10 December 2019

Re: New Catherine Field Primary School, O'Keefe Drive, Oran Park (SSD-9477)

Our primary concerns are as follows:

1. Height and Location of Buildings.
2. Verge Widths and Landscaping Along the Southern Boundary

PLANTING PLAN
1:200

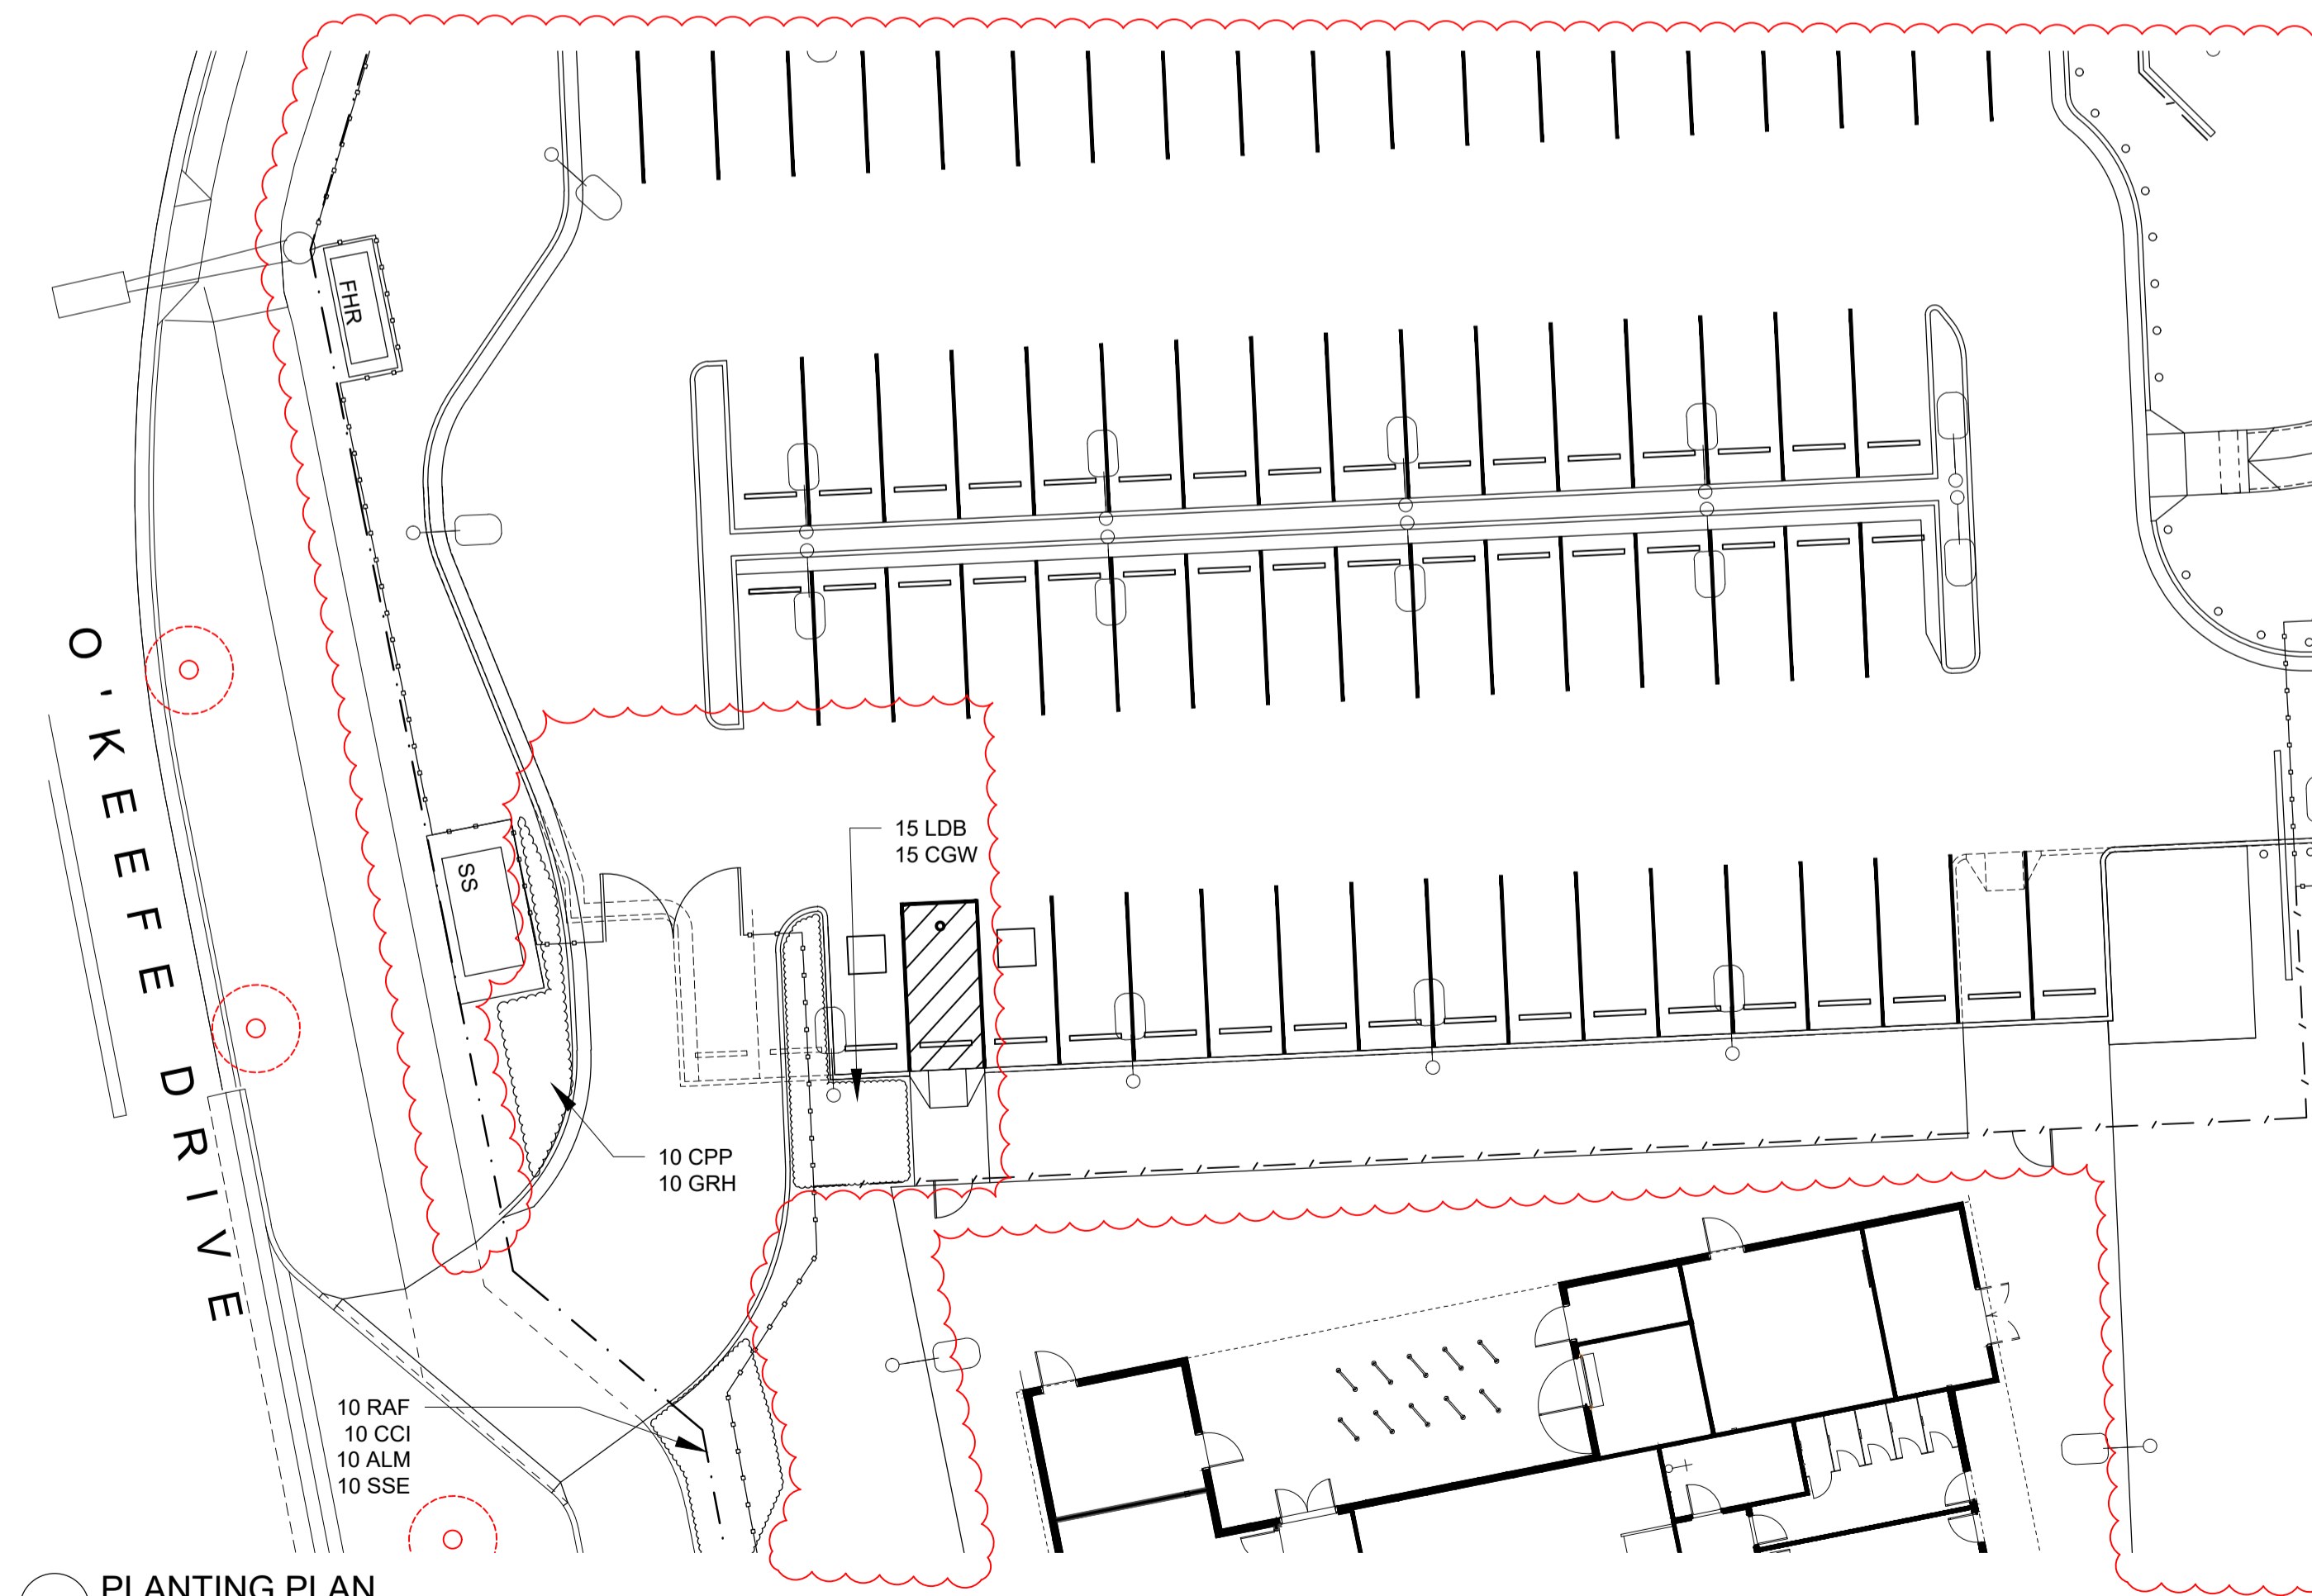
We also have concerns about the street and landscaping design along our common road. These issues have been raised previously. We understood that we had agreed certain outcomes with the Department but these have not been reflected in the design. These outcomes included:

- Widening the verge to accommodate a proposed cycleway
- Construction of the diplomat fencing behind the property line
- Articulation of the fence line and inclusion of architectural features
- Placement of a hedge and landscaping in front of the diplomat fencing
- Street landscaping and tree planting to a high standard in keeping with the surrounding areas.
